Request review of a vacation of portions of public right-of-way from 6th Street NW and Prospect Avenue NW (1,839 sq. ft), as part of our subsequent minor subdivision to create 1 new lot from 3 existing lots and the vacated portions. There are variance applications for the side and rear setbacks of the existing property to be heard at ZHE on 4/18/23.

**Plat for  
 Lot 1-A, Block 3, Apache Trail  
 Being Comprised of  
 Lots 1, 2 and 3, Block 3, Apache Trail; and  
 A Portion of Vacated 6th Street N.W. Right-of-Way  
 City of Albuquerque, Bernalillo County, New Mexico  
 March 2023**

**Re: Vacation of Public Right-of Way and subsequent Final Plat Review for Proposed Subdivision of Lots 1 thru 3, Block 3 of Apache Trail and Proposed Vacation of Portion of 6<sup>th</sup> Street N.W. Right-of-Way**

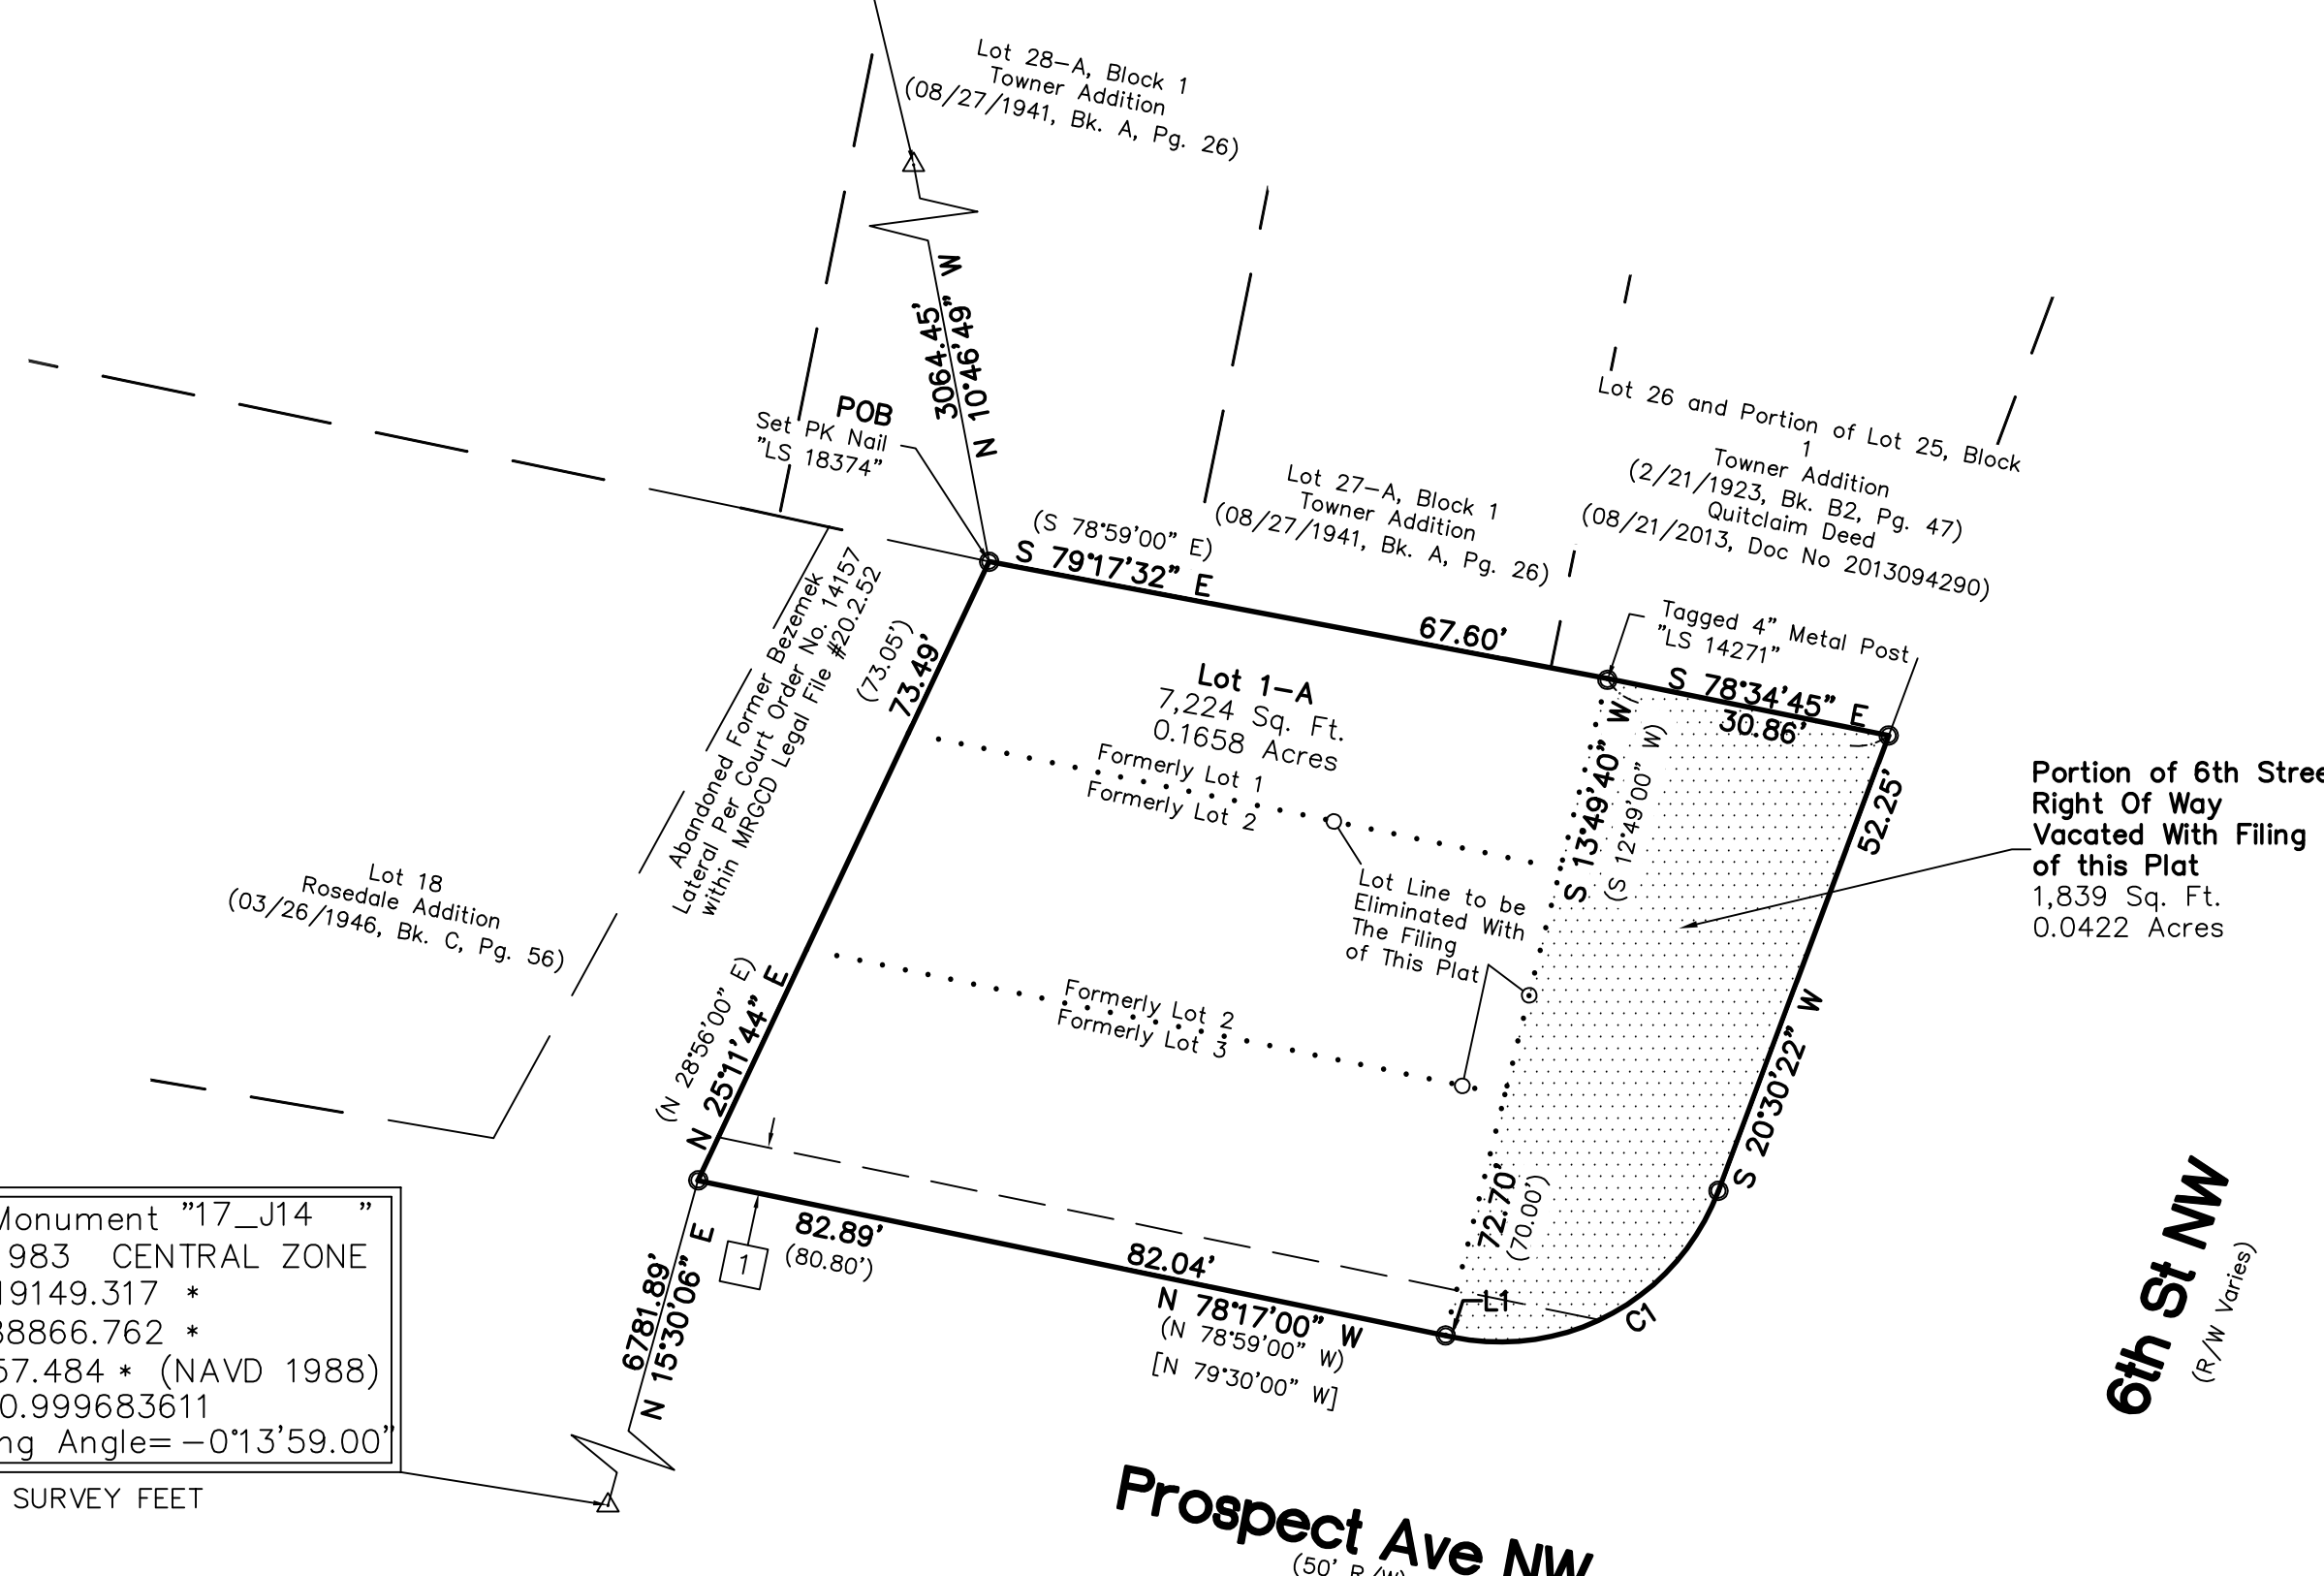
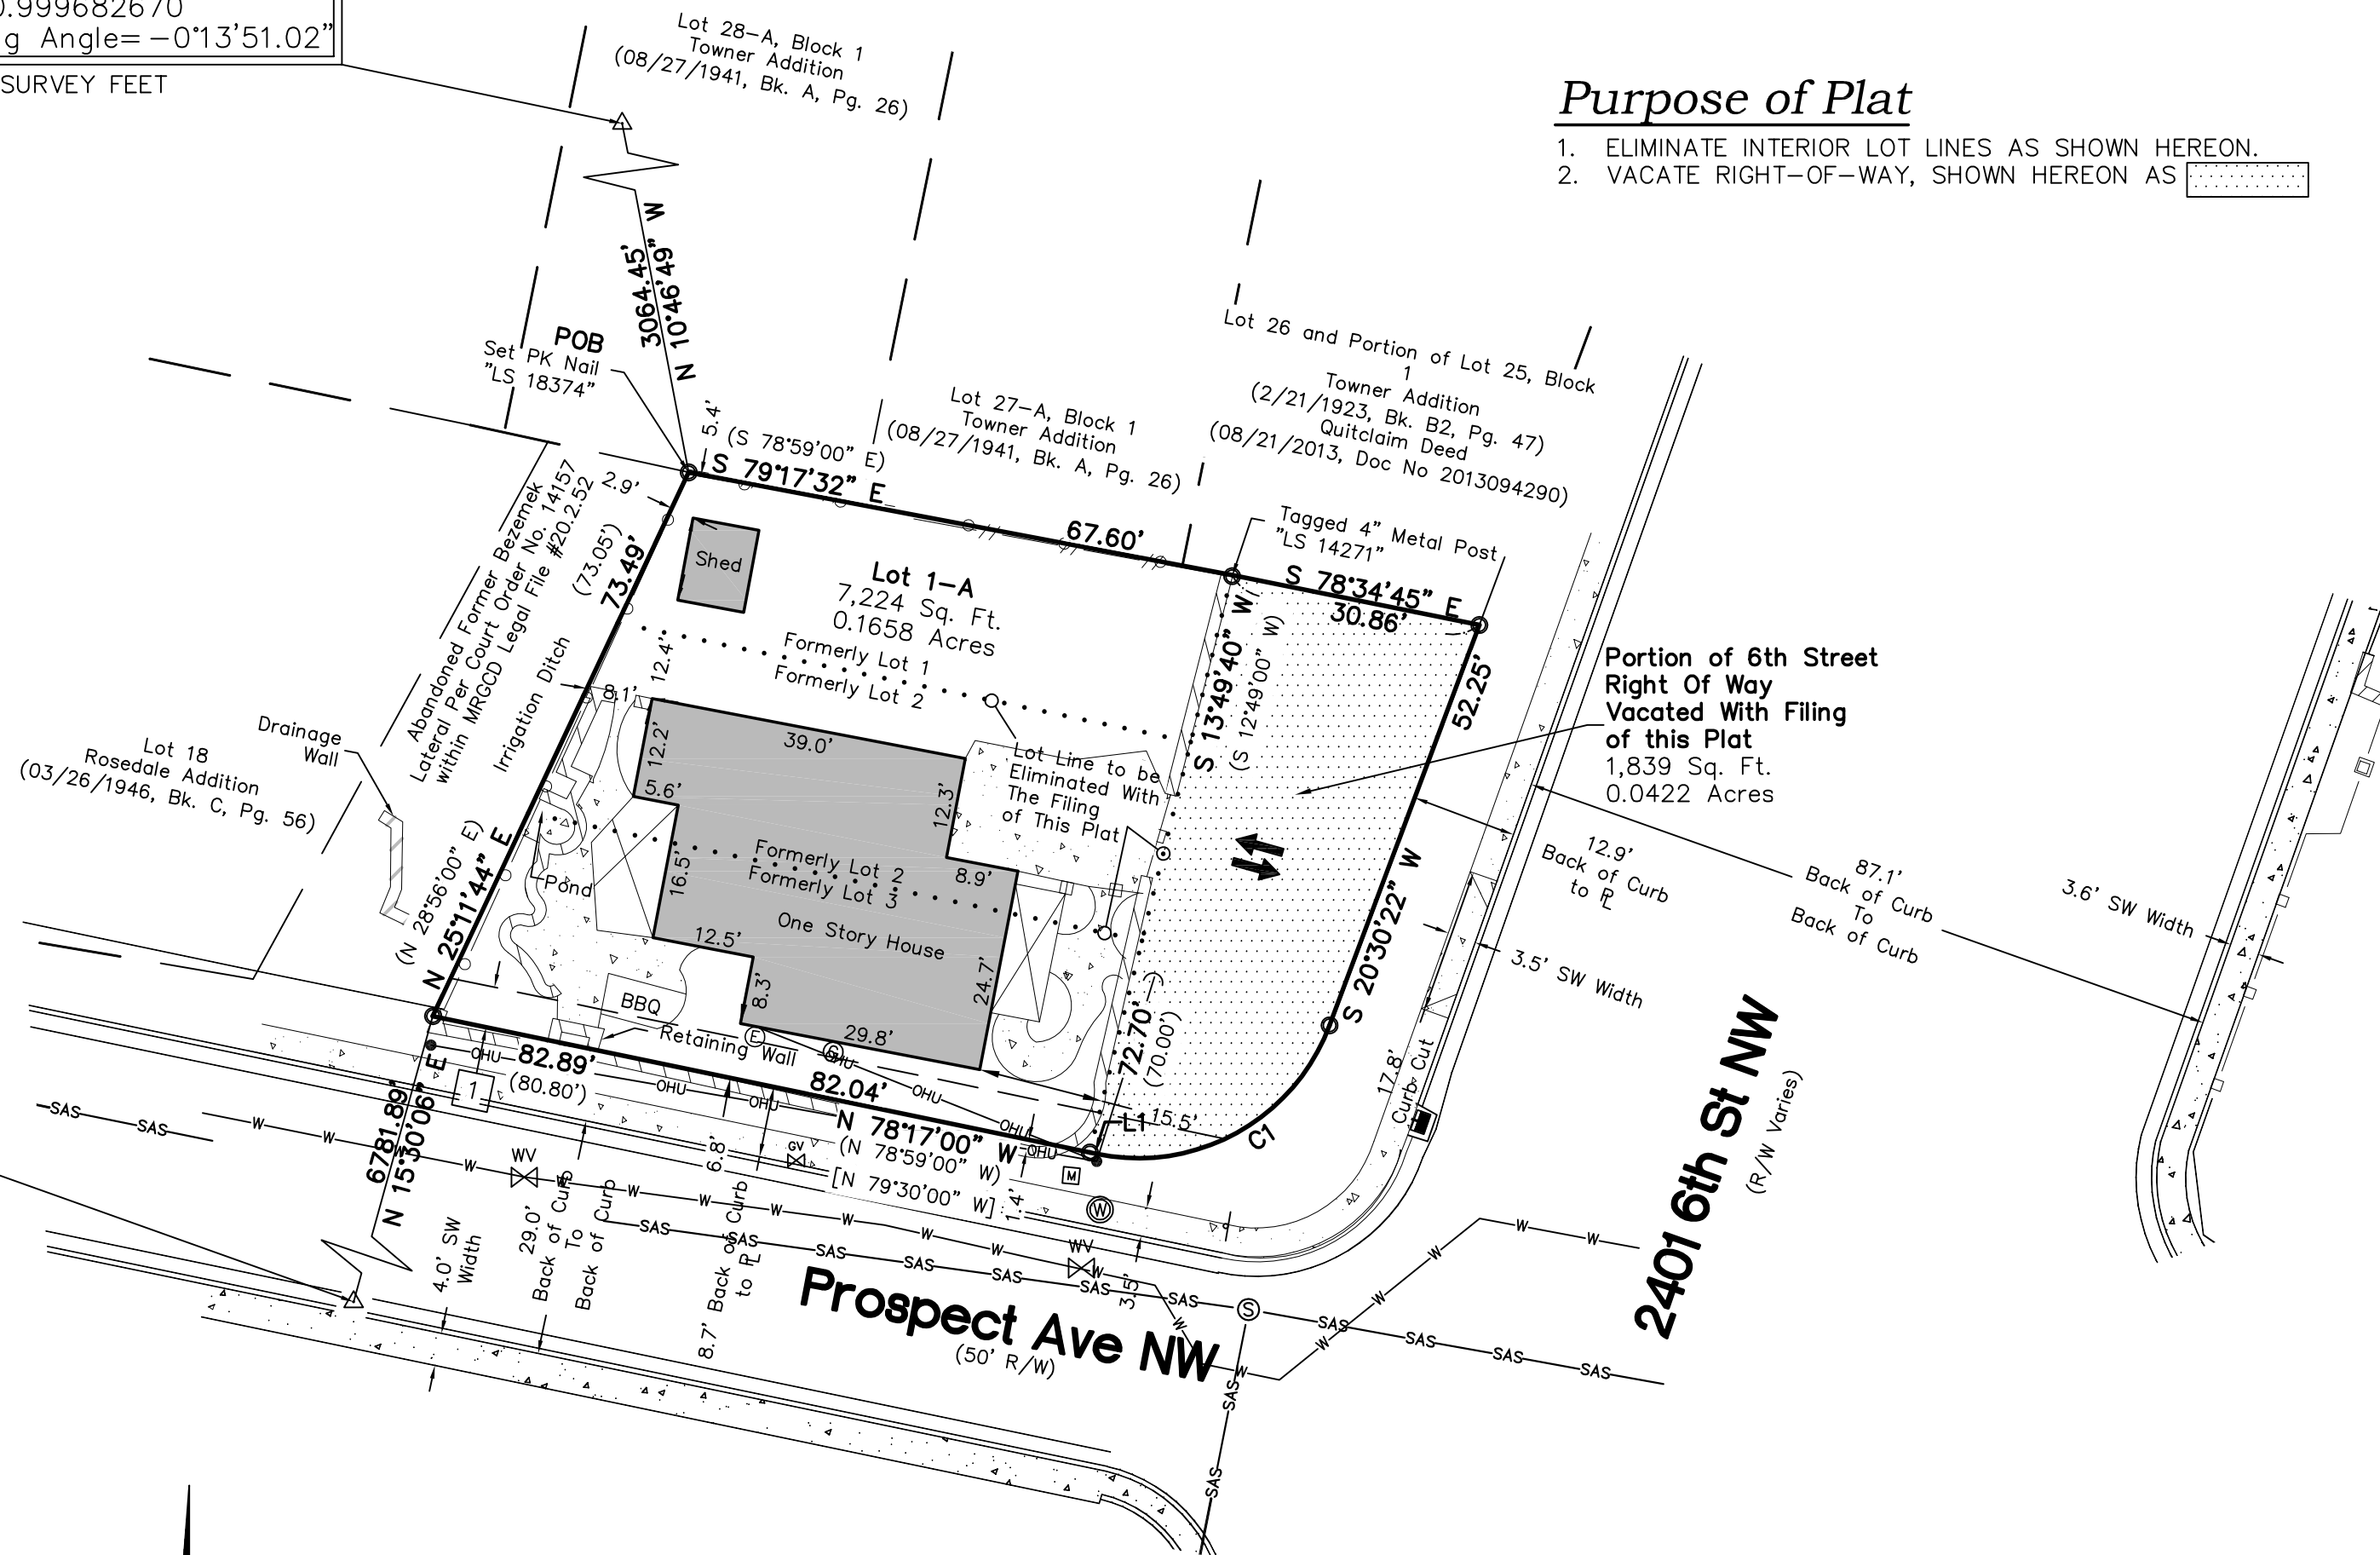
1. Property is zoned R-1A, Residential single-family zone district, and must meet all Dimensional Standards of IDO section 5-1, Table 5-1-1 (Front = 10 ft, Side on corner lot = 10 ft, Interior side = 5 ft; Rear = 10 ft).
2. Prior to submittal for re-plat, you must apply to Zoning Hearing Examiner for a Variance for the following setbacks not being met:
  - a. Side Setback on corner lot street side shows as 6.8 feet, and 10 feet is required.
  - b. Rear Setback shows as 8.1 feet, and 10 feet is required.
3. Though this property is located in an Area of Consistency, there is no new development being performed; therefore, section 5-1(C)(2)(b) for Contextual lot size requirements is not applicable.

Noted, we have requested a variance from the ZHE for side and rear lot setbacks, to be heard on April 18<sup>th</sup>, 2023. This is noted on our proposed plat sheet 2.

6th Street NW

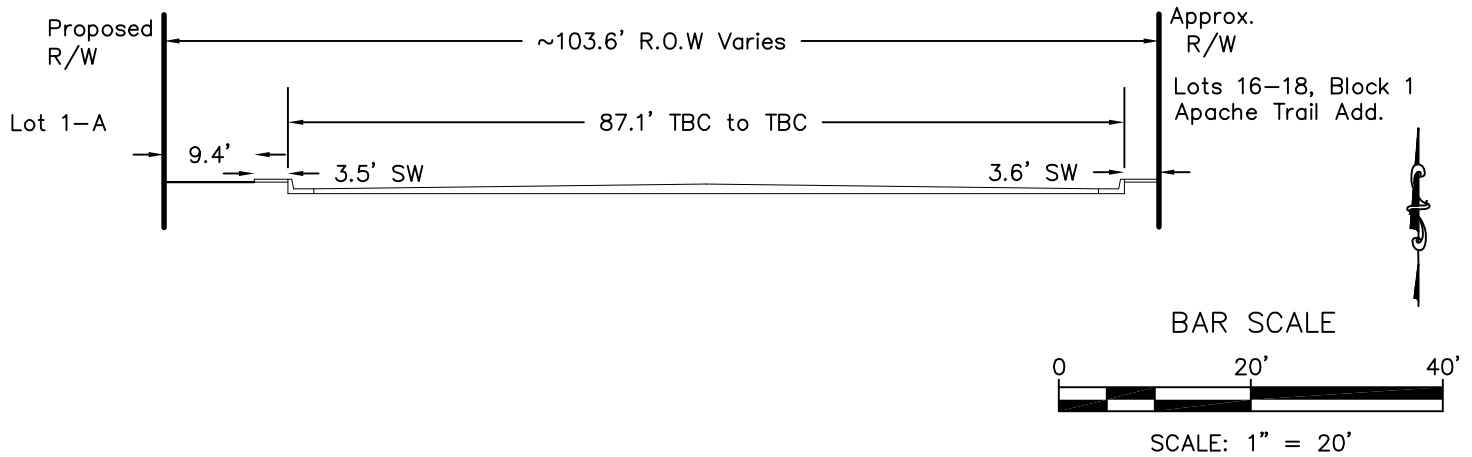
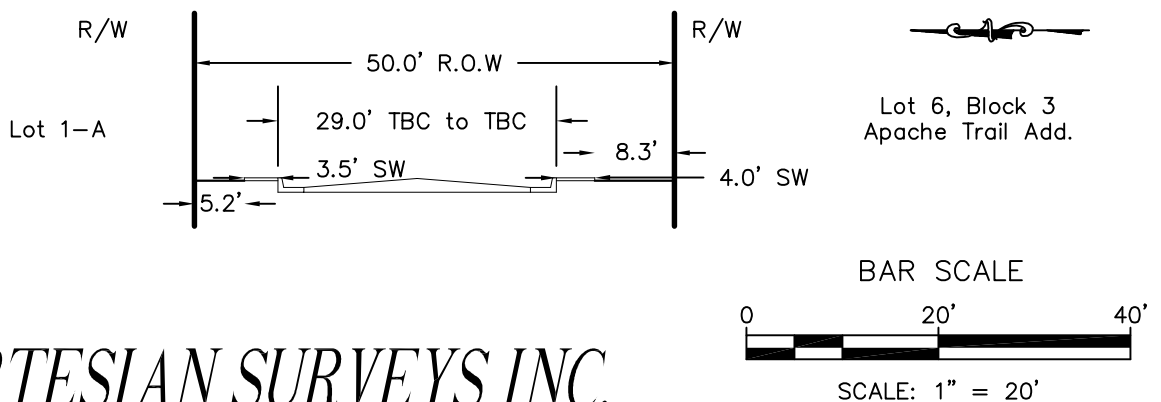
1. Please provide cross-sections at both 6th St. and Prospect Ave. showing dimensions for ROW line, sidewalks, curb and gutter to ensure these meet current DPM standards. Provide a plan which indicates the existing curb cut width including dimensions to the nearest property line.

Noted, see attached cross-section for the 6<sup>th</sup> Street and Prospect Ave rights-of-way, and curb cut along 6<sup>th</sup> Street NW.
